Smithy Place Lane, Honley
HD9 6PR

Stage 1 Road Safety Audit

Report title:	Stage 1 Road Safety Audit
Date:	17th September 2026
Document reference and revision:	169955-001-02
Prepared by:	Sanderson Associates
On behalf of:	Kirklees
	Council (Overseeing Organisation)

Drawing Title
**Proposed Public Rights of
Way Improvements**

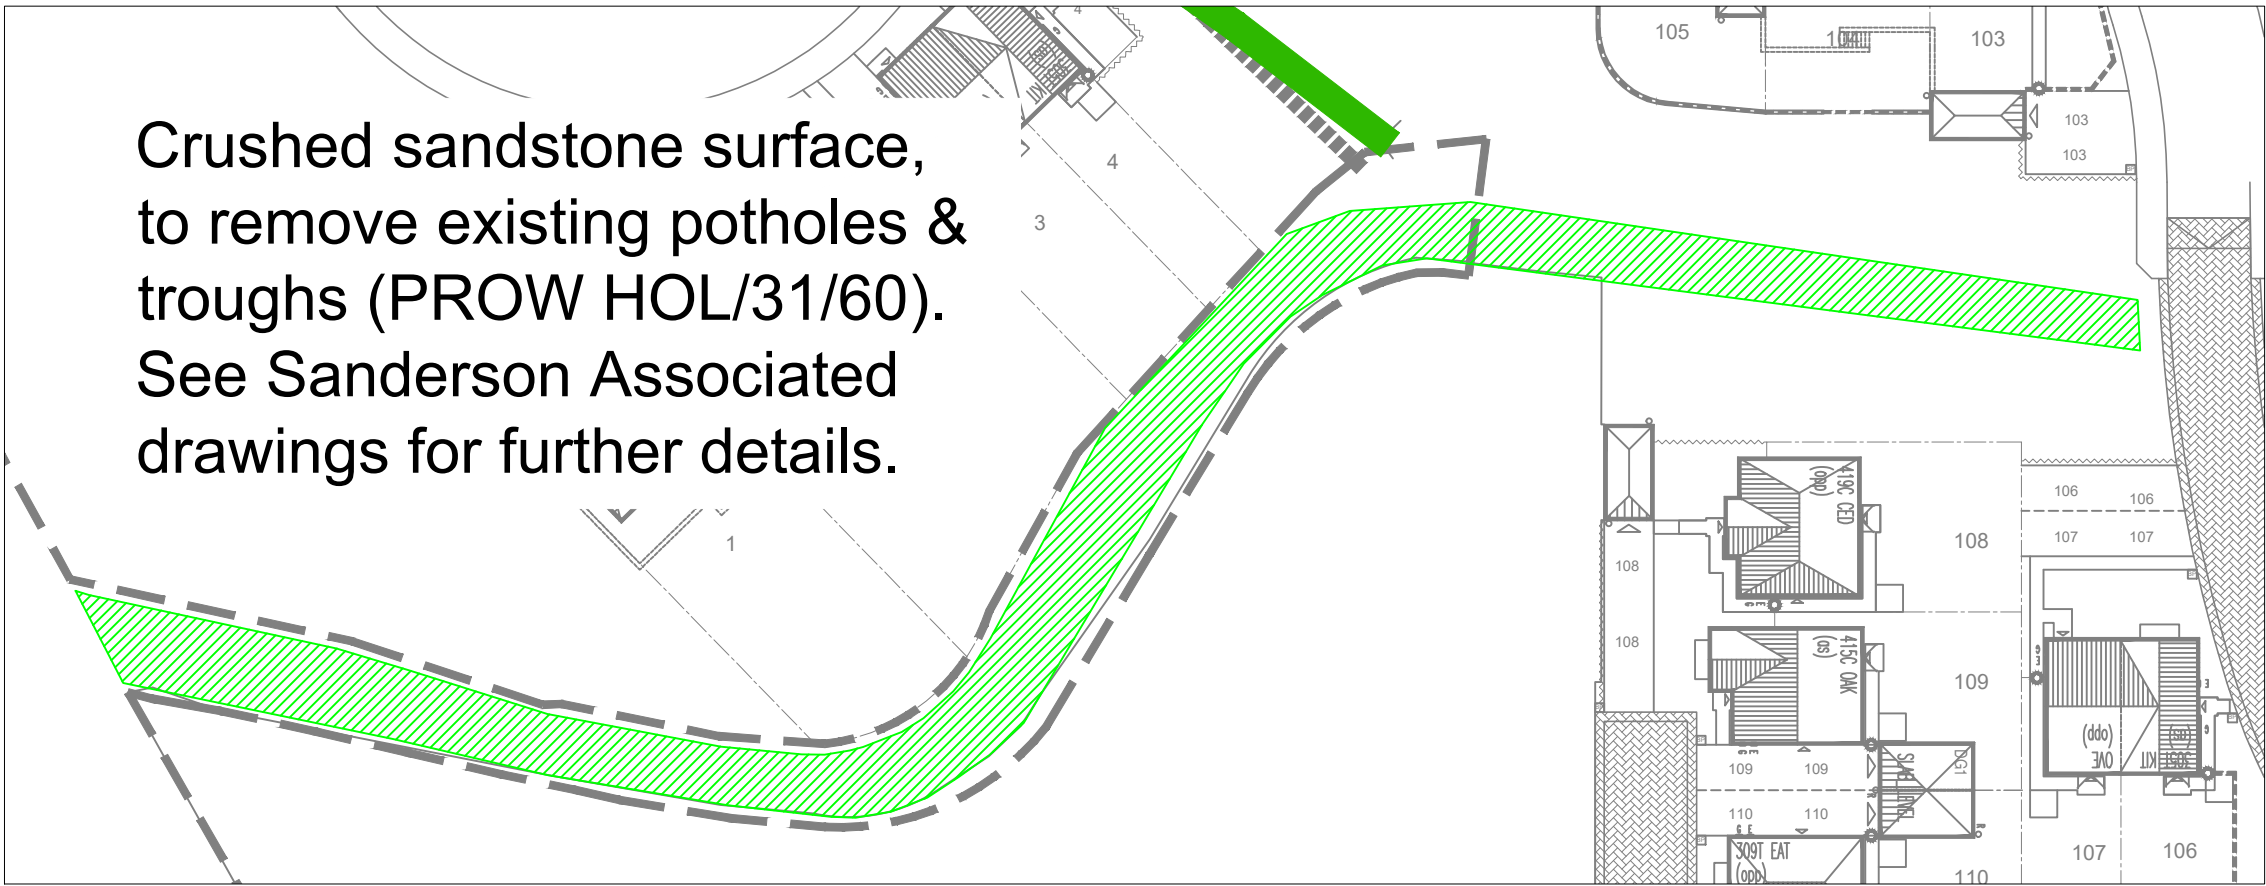
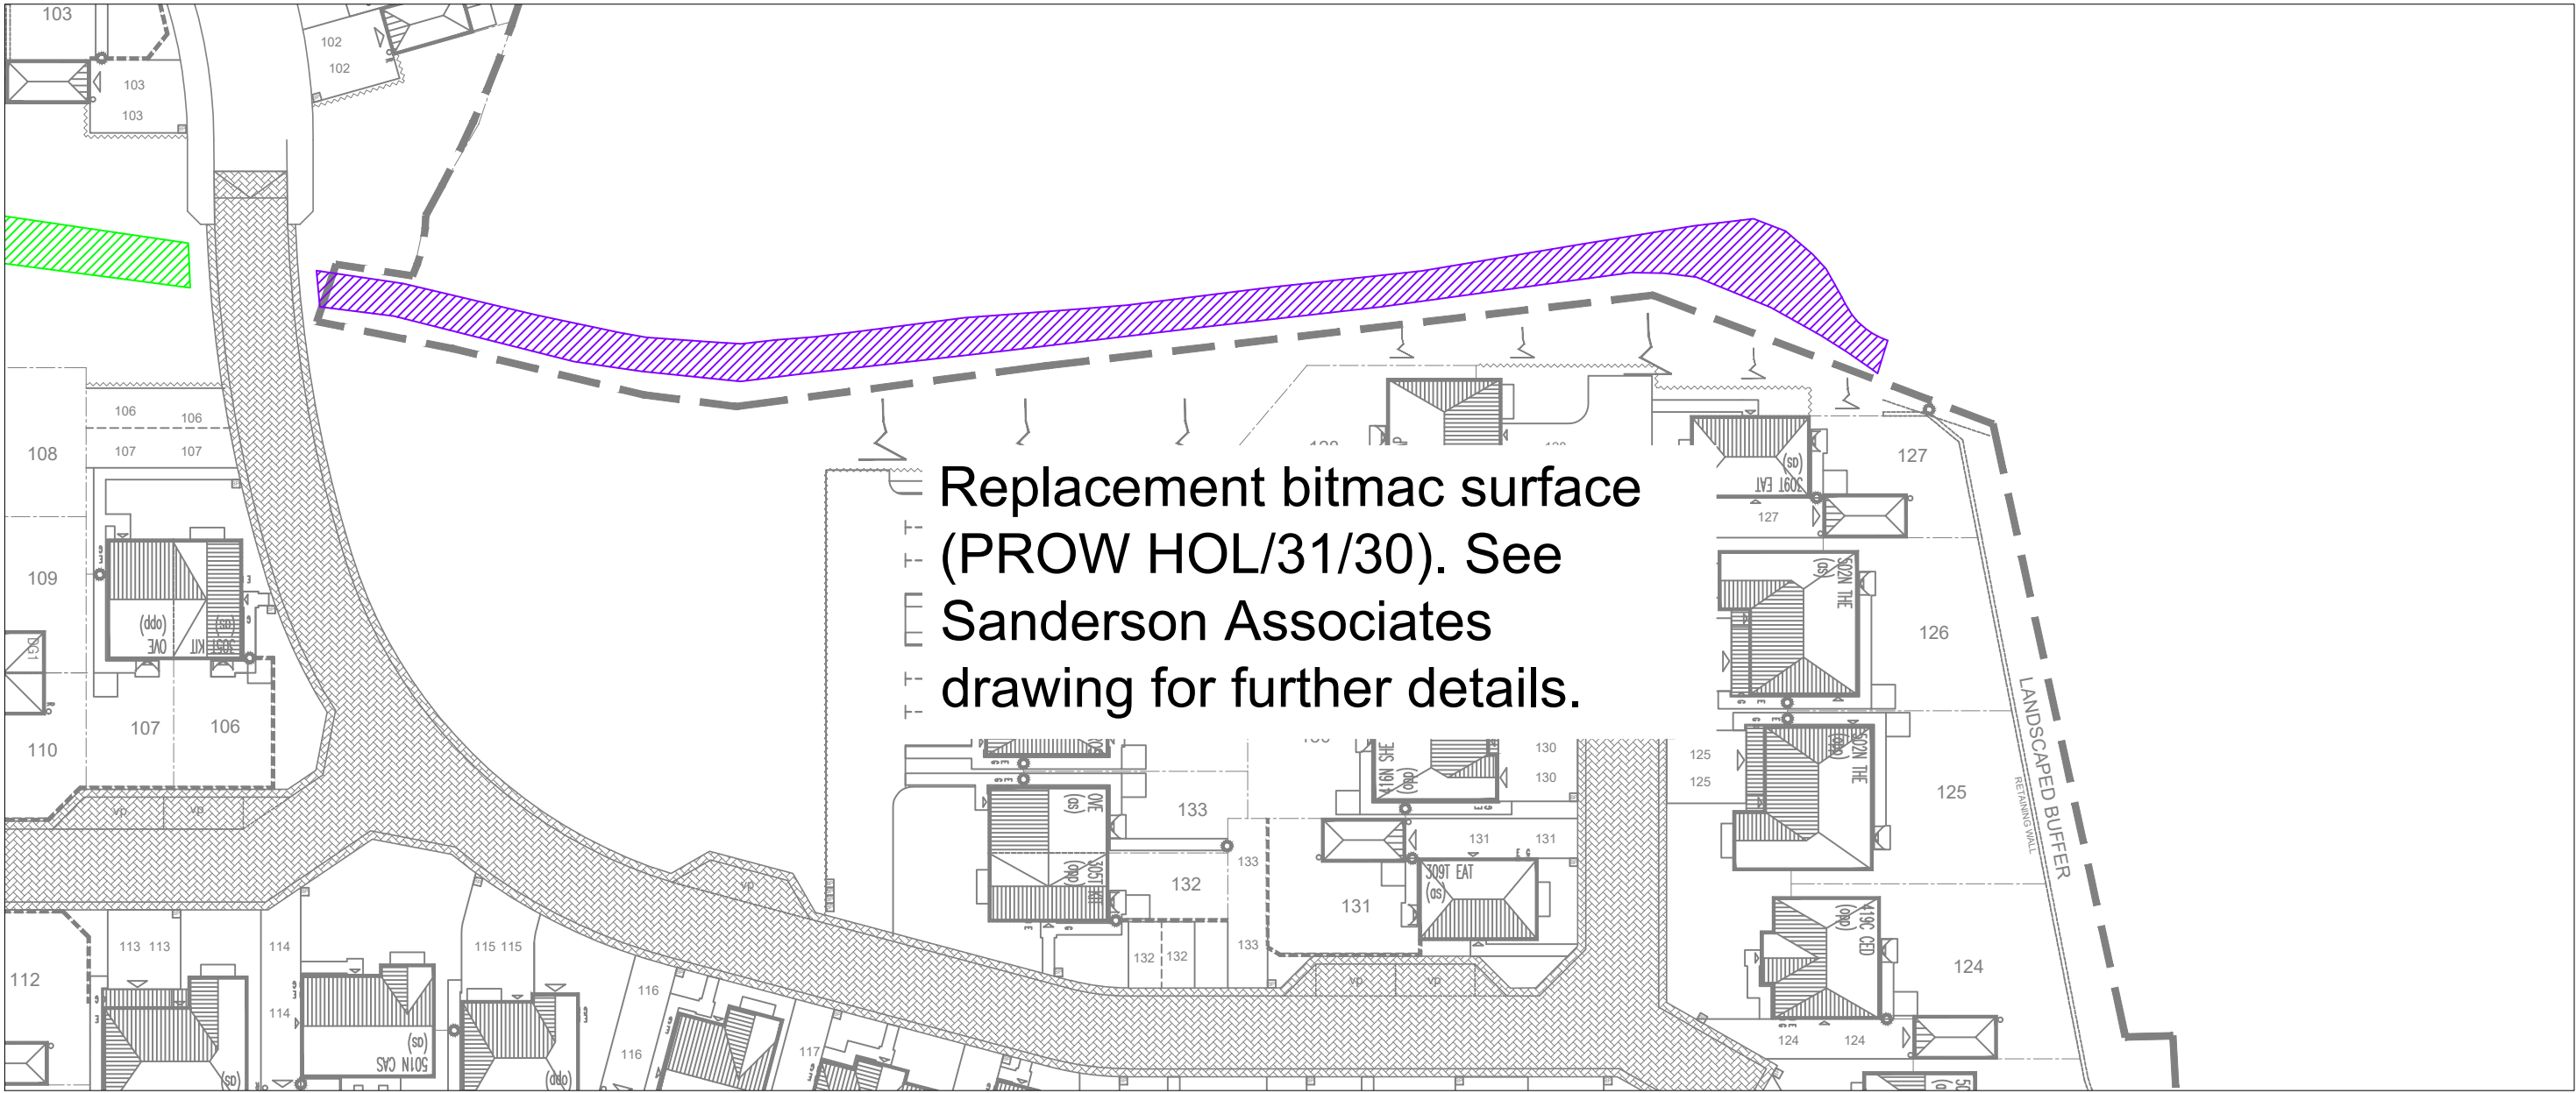
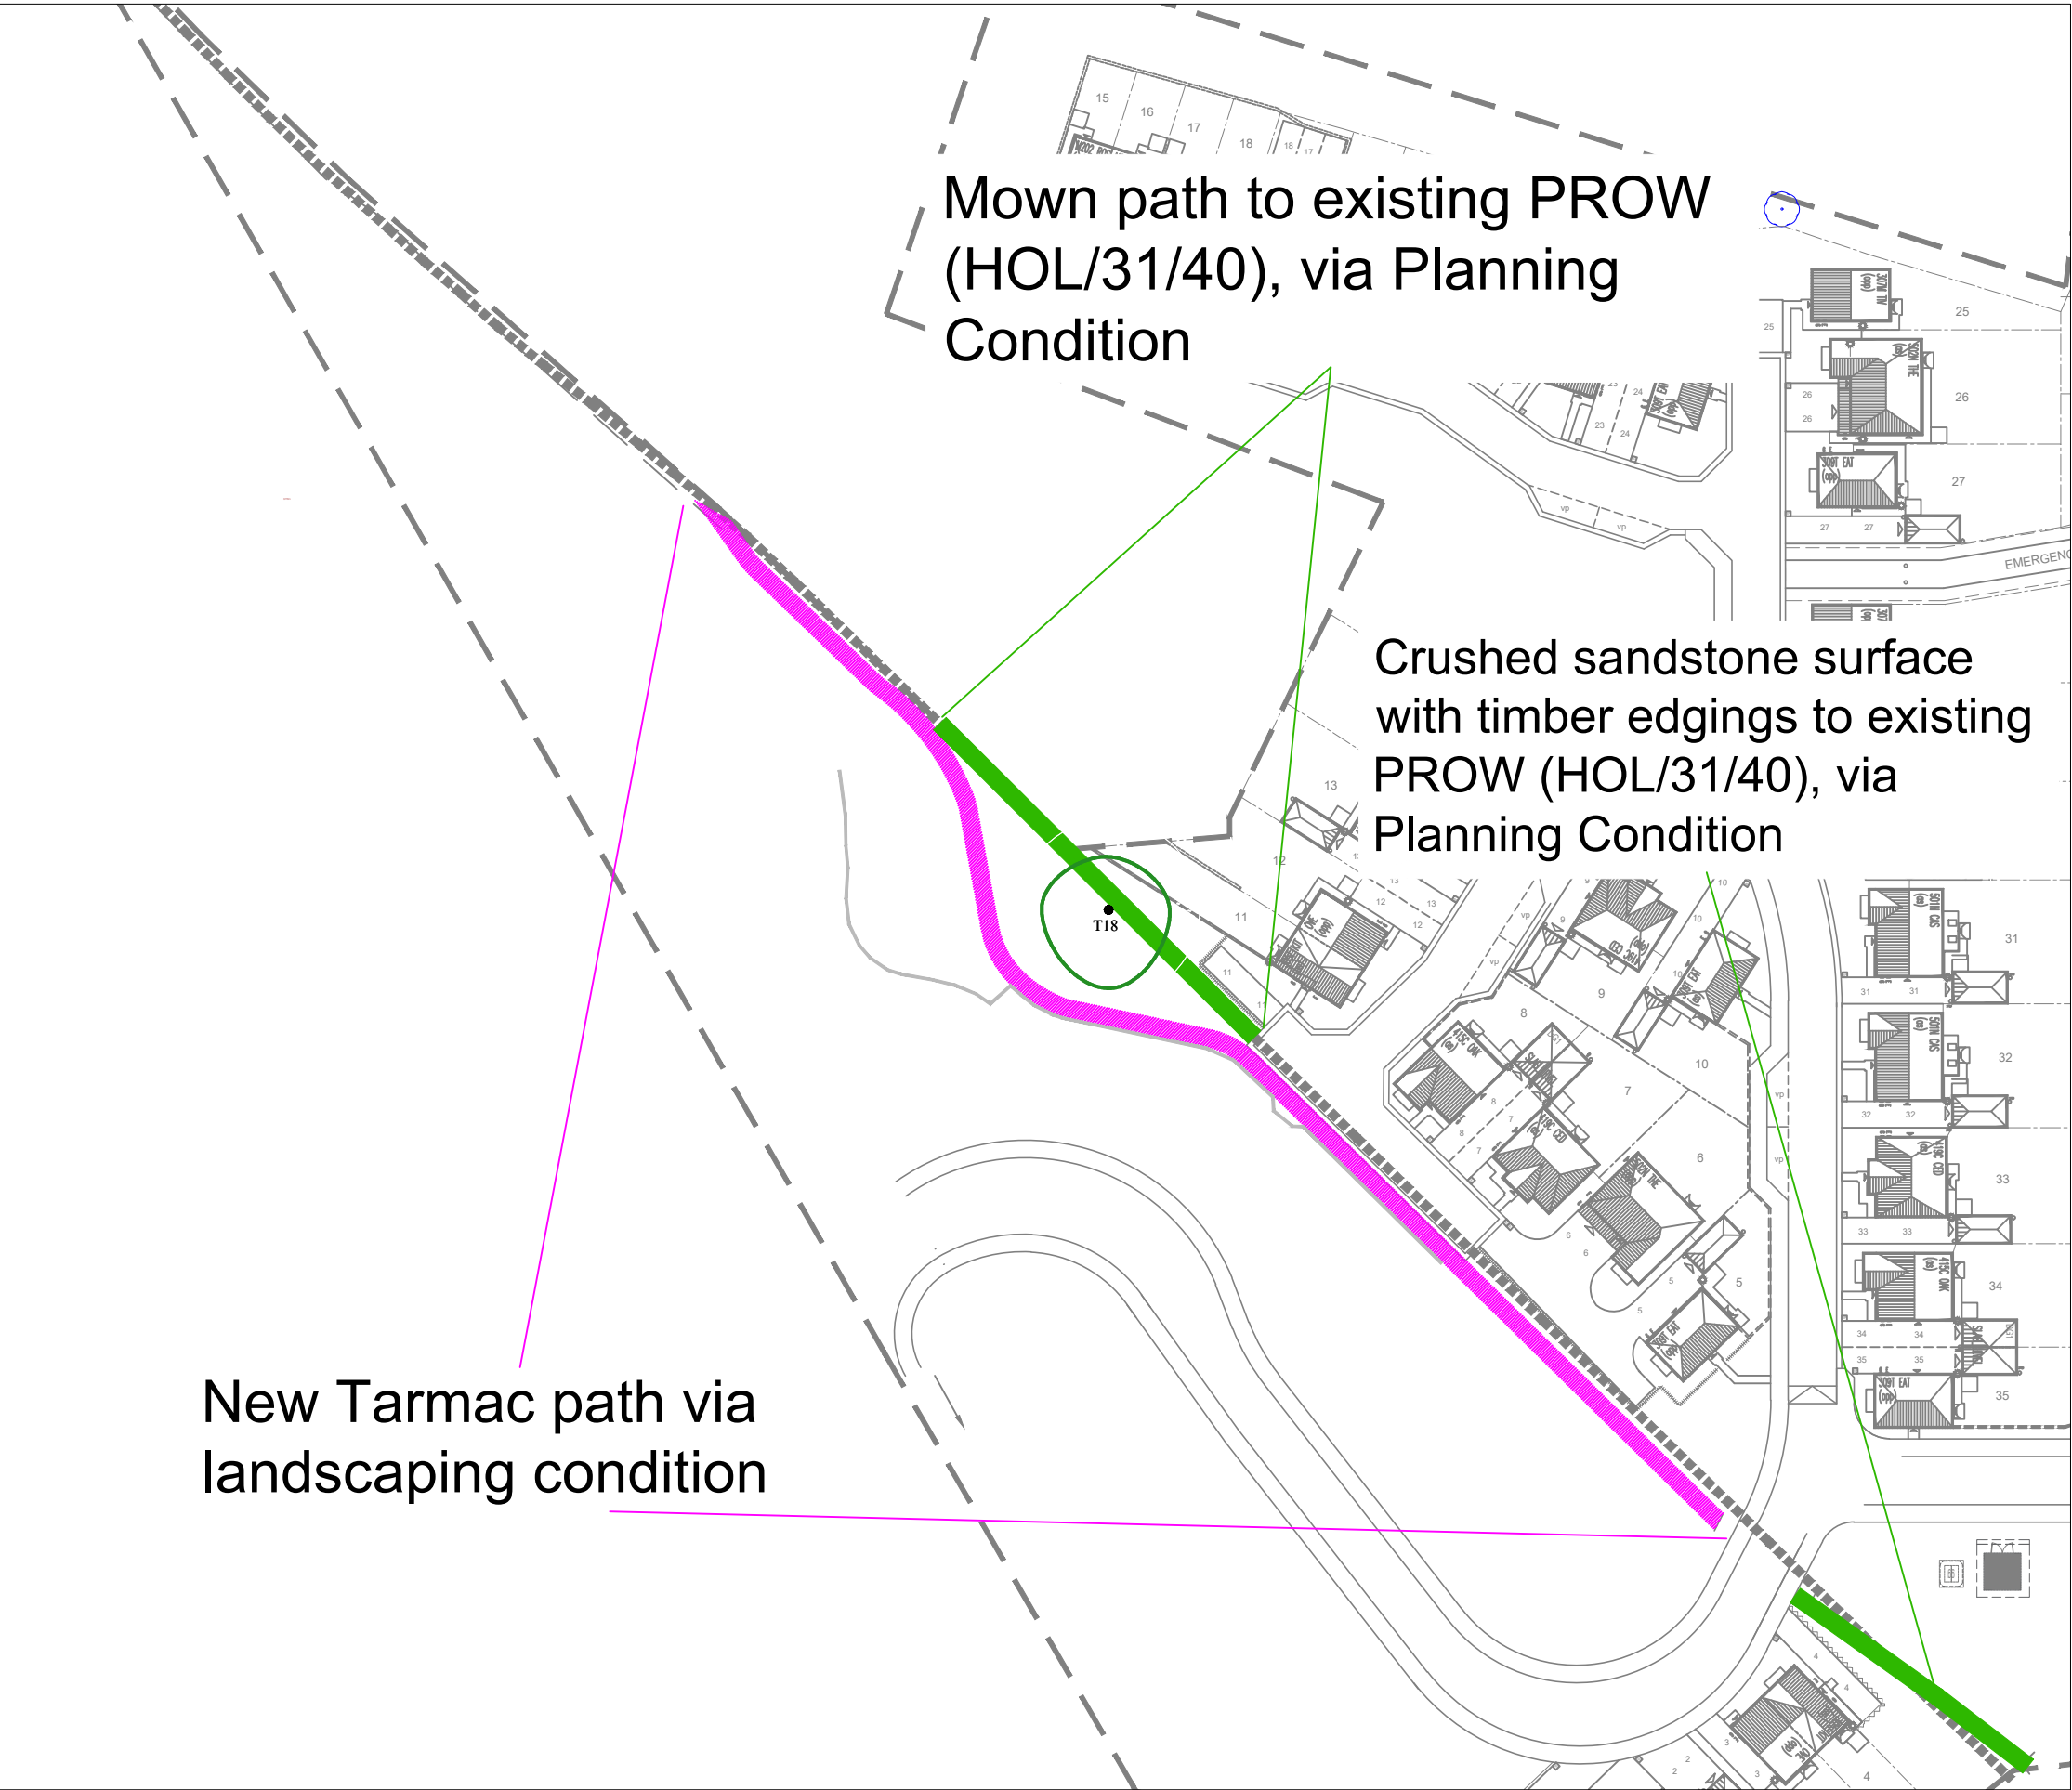
Location: Smithy Place near Oak Way.

Summary: Potential vehicular access to the residential development

Detail: Vehicular access to the properties on Smithy Place is currently, and should remain, solely from the existing junction with Smithy Place Lane. However, the improvement works widen and improve the surface of the PROW, particularly along the short section beyond the last residential property, up to the crossing point on Oak Way, and the design includes a sign at the Oak Way crossing reading "public bridleway vehicle access only to property on Smithy Place". This wording, combined with the improved surface and width, does not preclude use of this section by existing residents seeking to egress into the Miller Homes development, nor does it prevent non-resident drivers from within the development using it to access Smithy Place or as a through route to Smithy Place Lane. Retaining any vehicular function on this short section introduces unnecessary conflict between vehicles and pedestrians, cyclists and equestrians, on a link that could otherwise be designed to promote NMU use exclusively. There doesn't appear to be an operational need for this section to accommodate vehicles in either direction, given that suitable vehicular access already exists via Smithy Place Lane.

Recommendation: It is recommended that the short section of PROW between the last residential property on Smithy Place and the Oak Way crossing is designed and signed to exclude vehicular access in both directions, including access/egress by existing Smithy Place residents, with a physical measure - such as a bollard, gate, or other restriction appropriate to NMU use - provided at this point, and that the proposed sign wording at the Oak Way crossing is amended to remove any reference to vehicle access, so that the existing junction with Smithy Place Lane remains the sole point of vehicular access to the properties on Smithy Place.
